Tel: 01903 737756
Email: planning@arun.gov.uk
www.arun.gov.uk/planning
Please ask for: Laura Mills
Email: laura.mills@arun.gov.uk
Telephone: 01903737794
Our Ref: EP/55/26/HH
Your Ref:
Date: 5th June 2026

Application for Planning Permission for Works or Extension to a Dwelling

Development: Replacement of first floor rear glazing.
Location: Vista Point 21 Tamarisk Way East Preston BN16 2TE

DRAWING
EXISTING PLAN AND ELEVATIONS

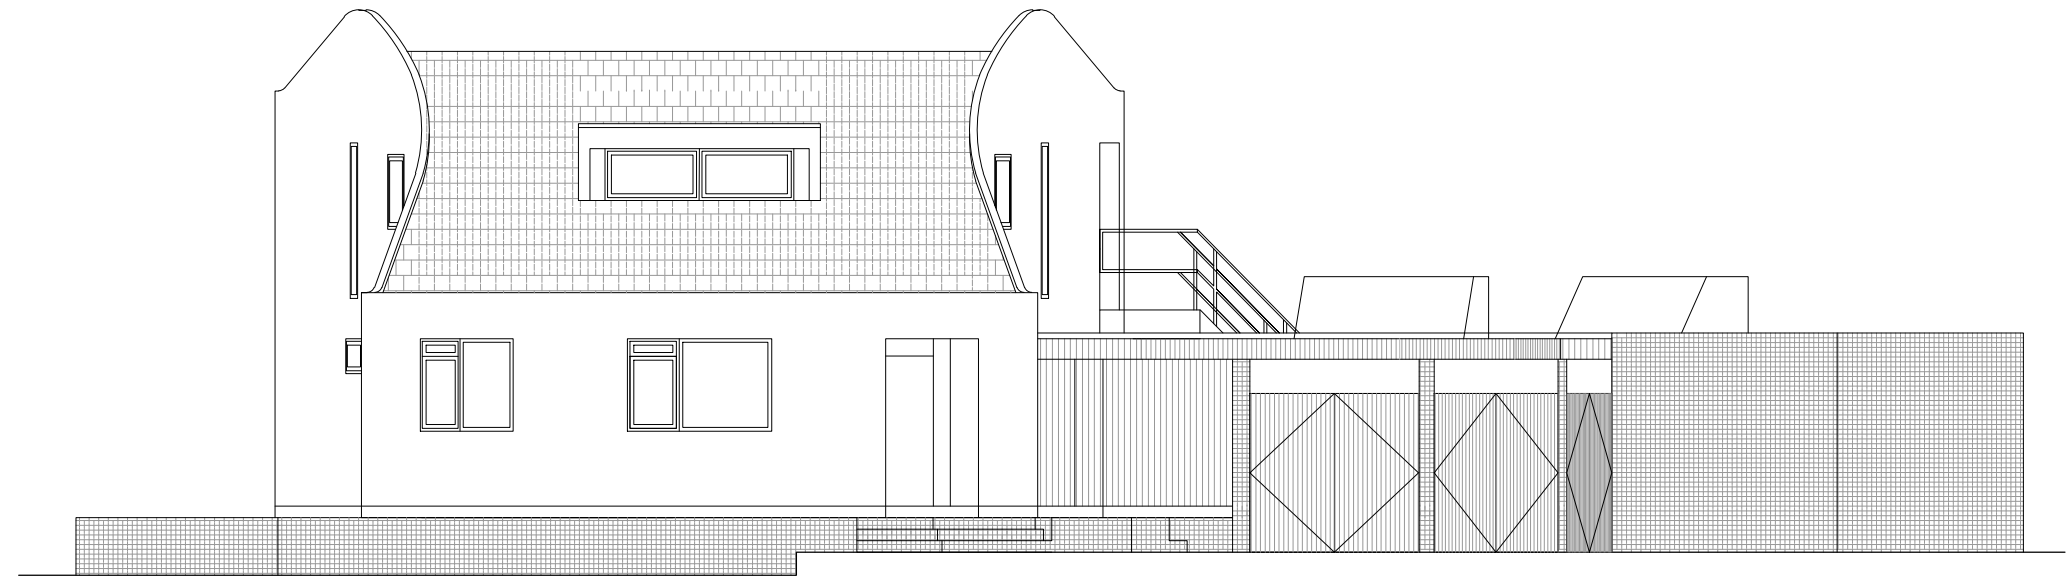
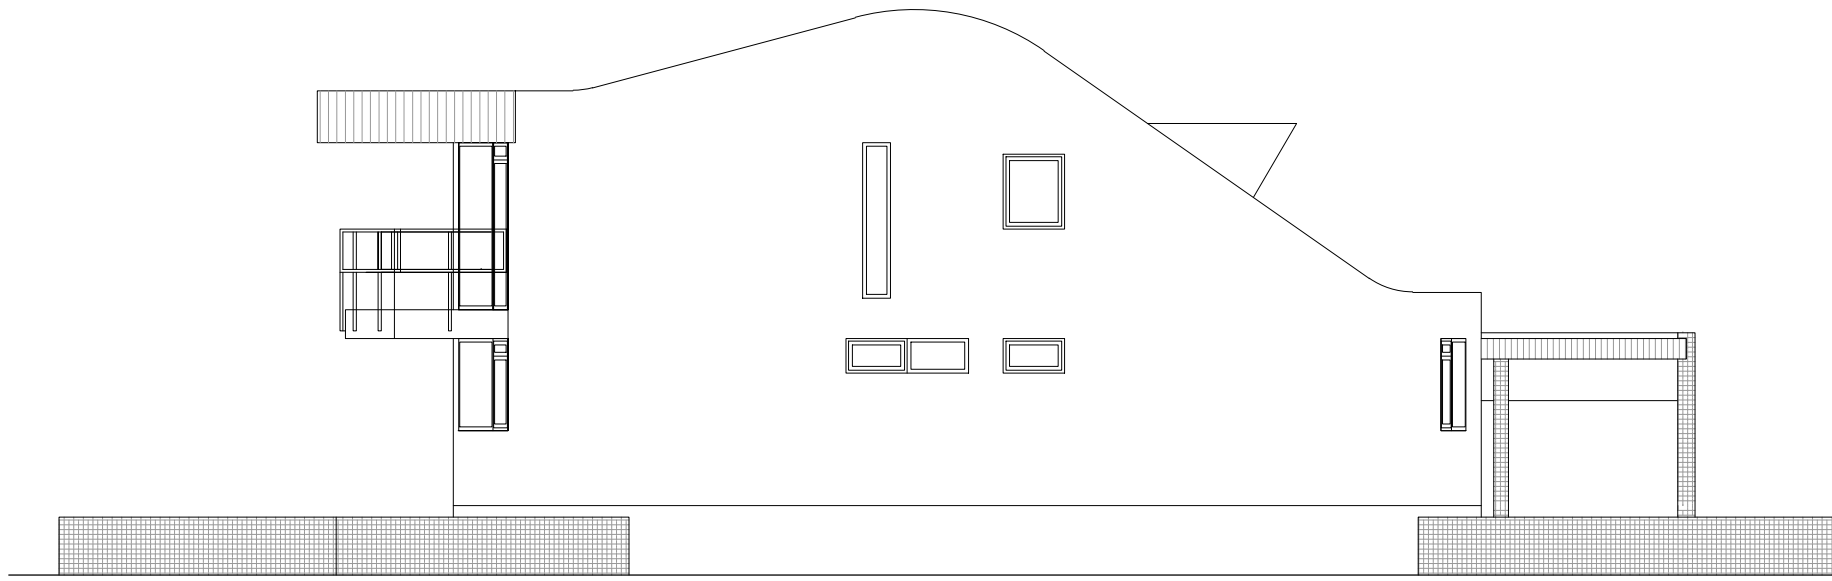
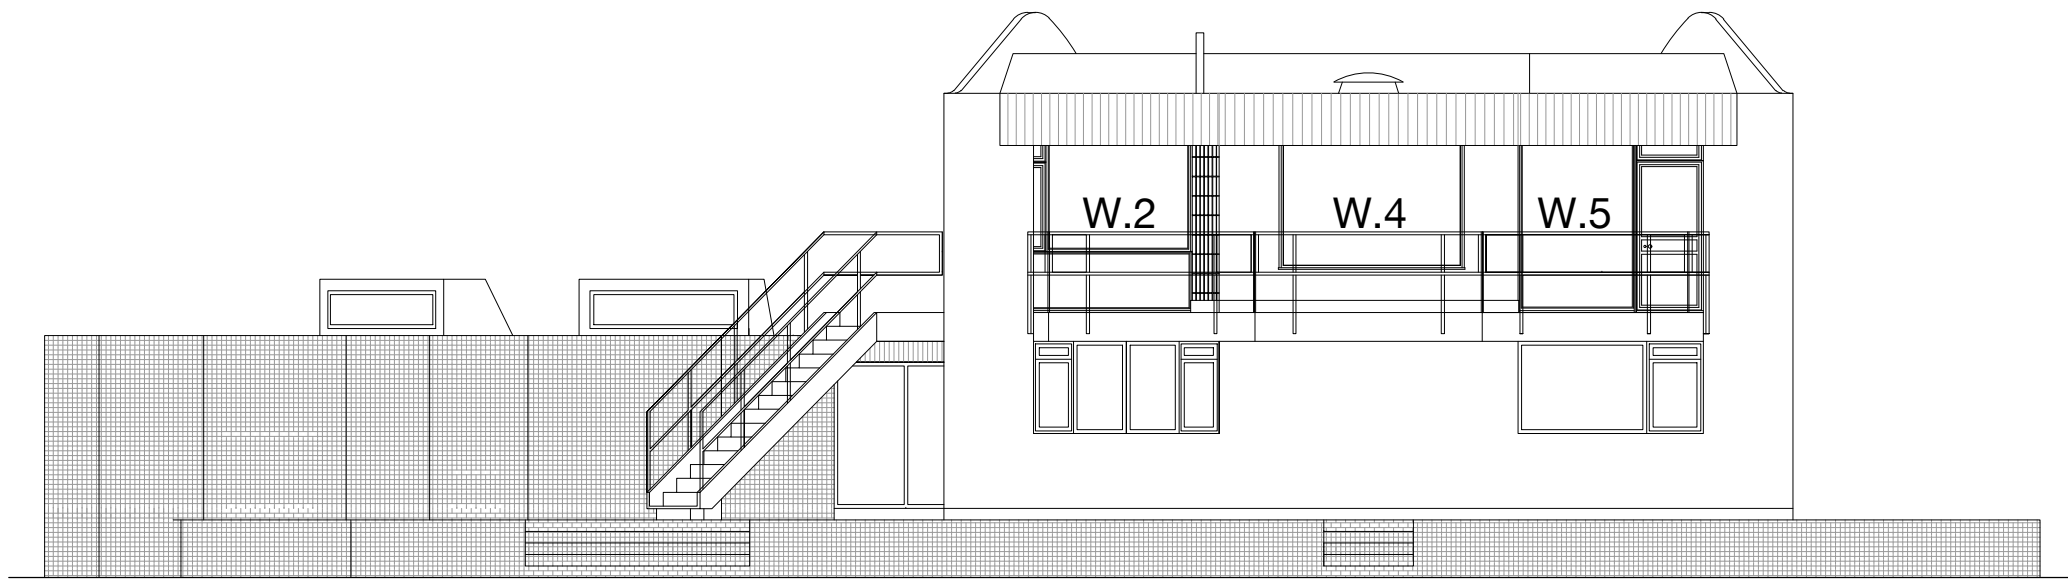
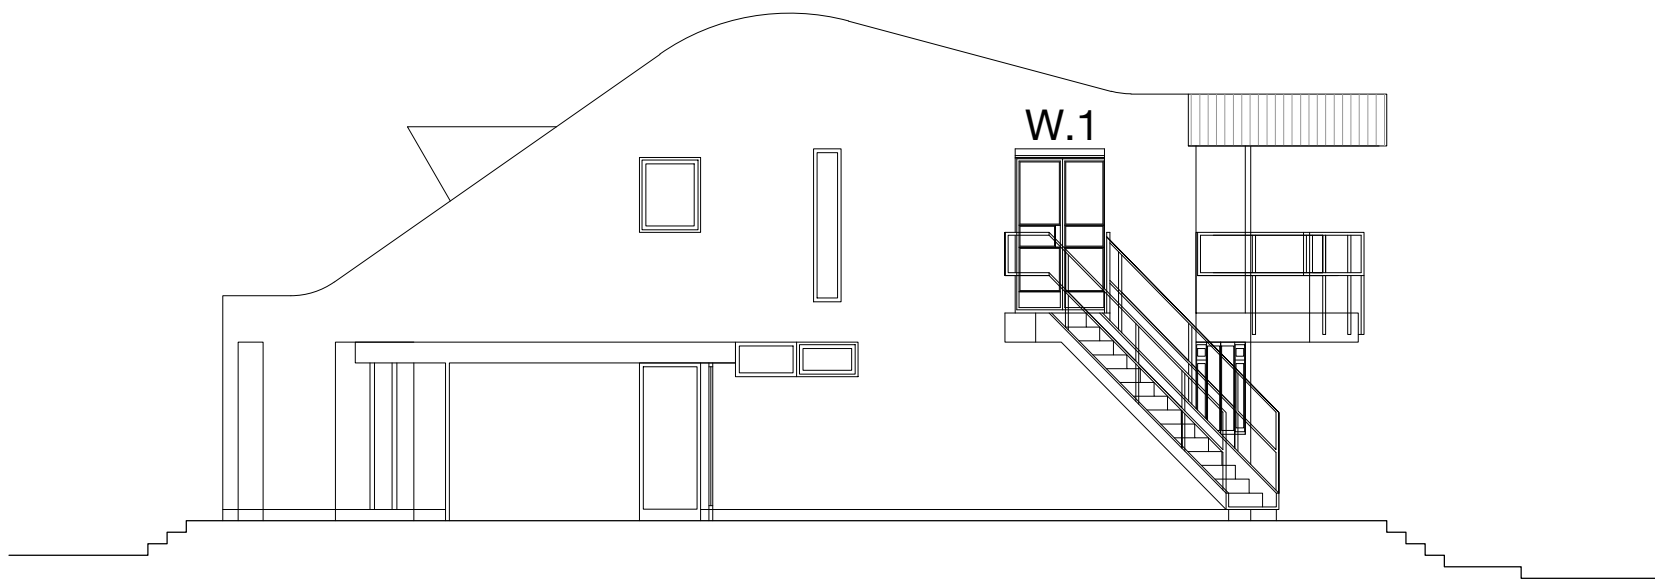
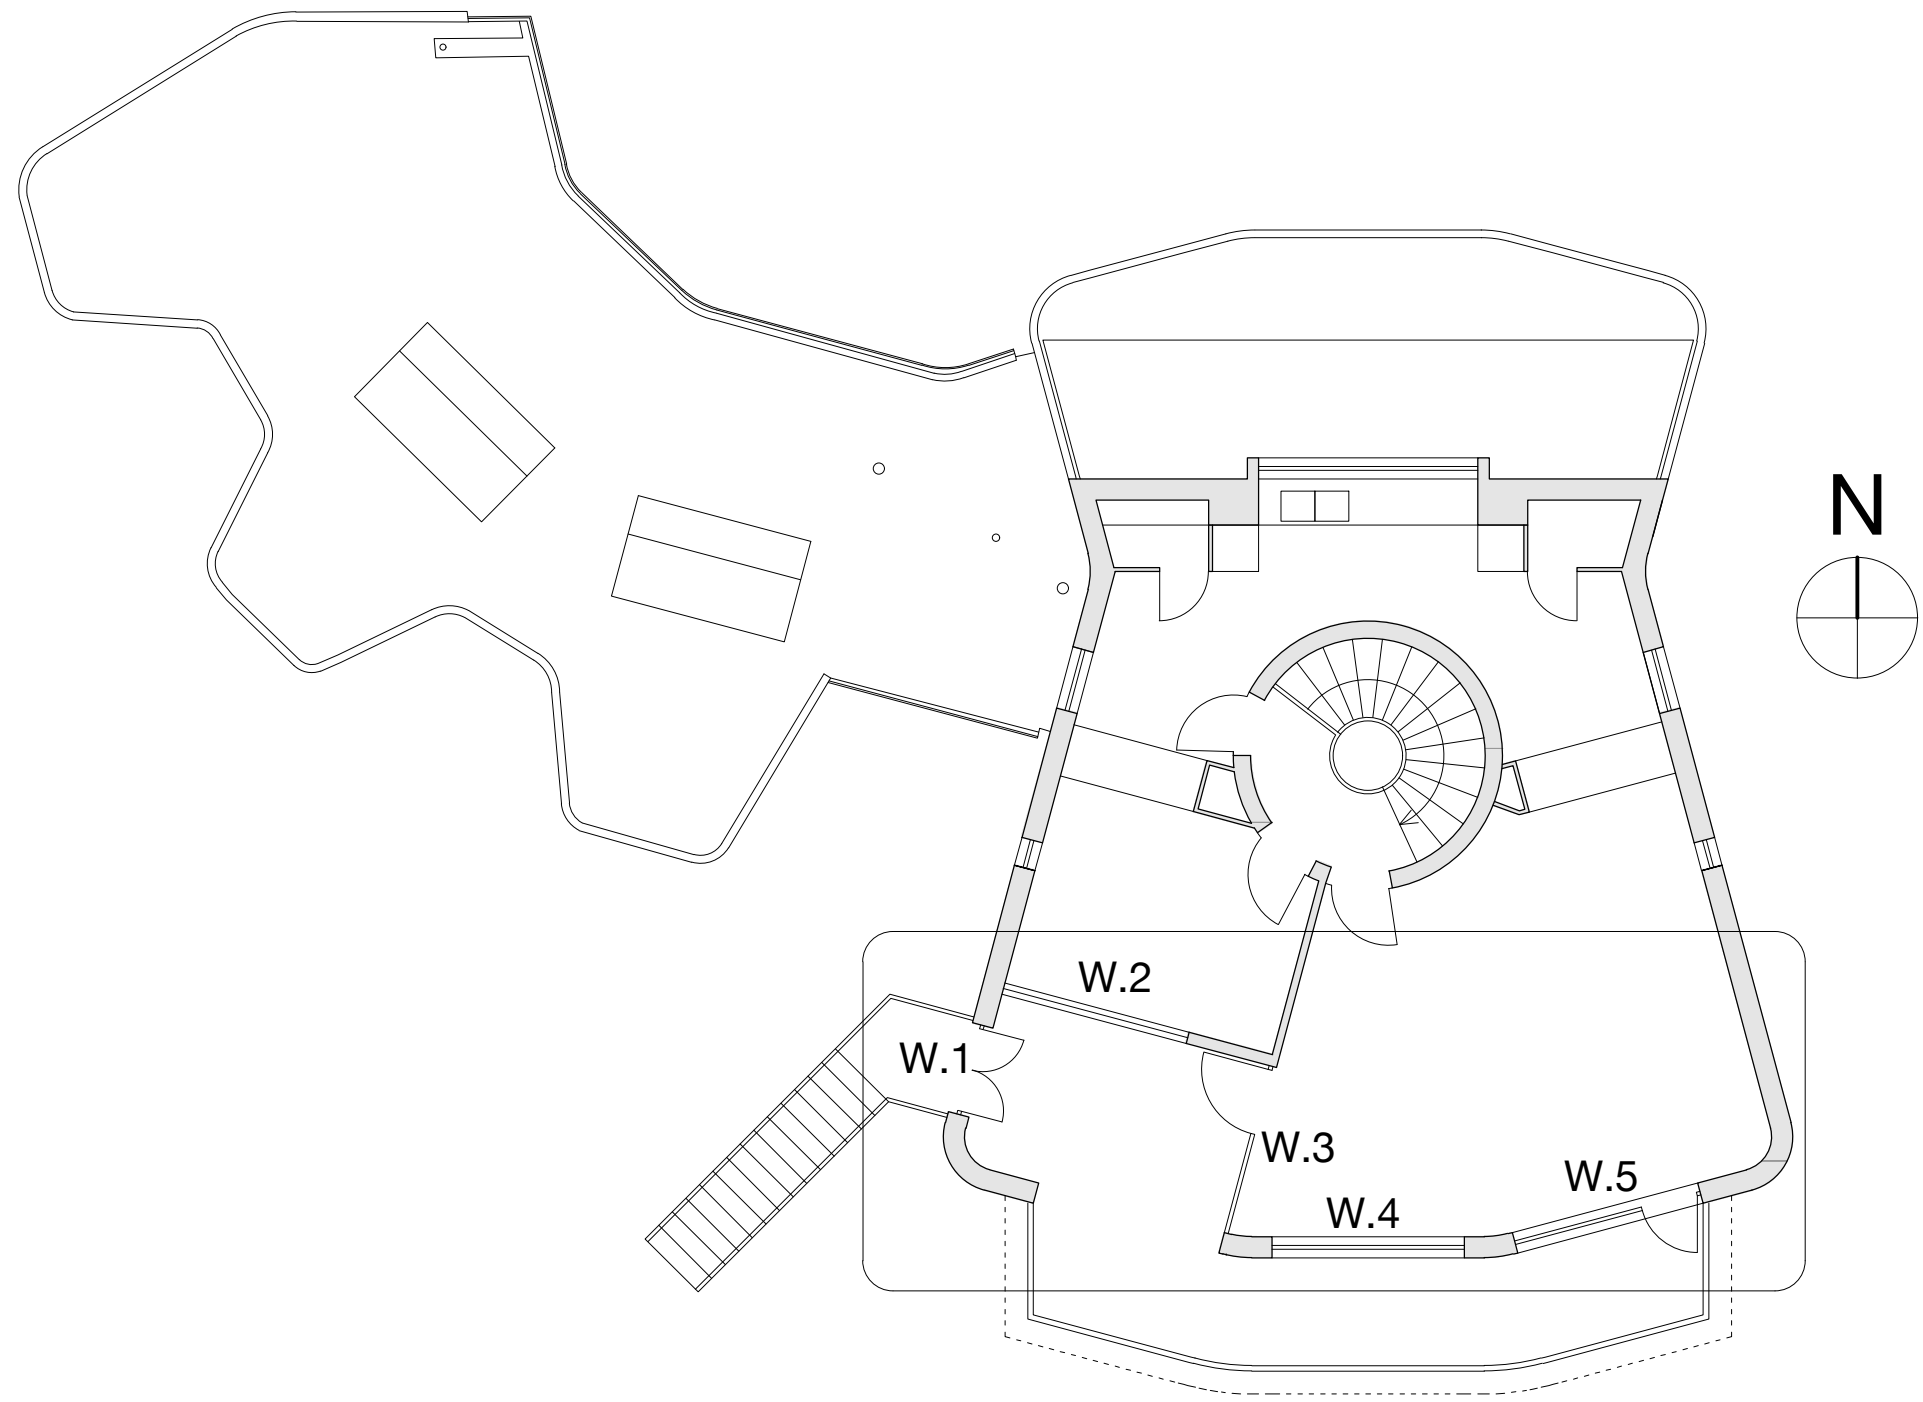
The scale bars on the proposed and existing elevation plans do not scale at 1:100. Existing and proposed elevations should either be 1:50 or 1:100.
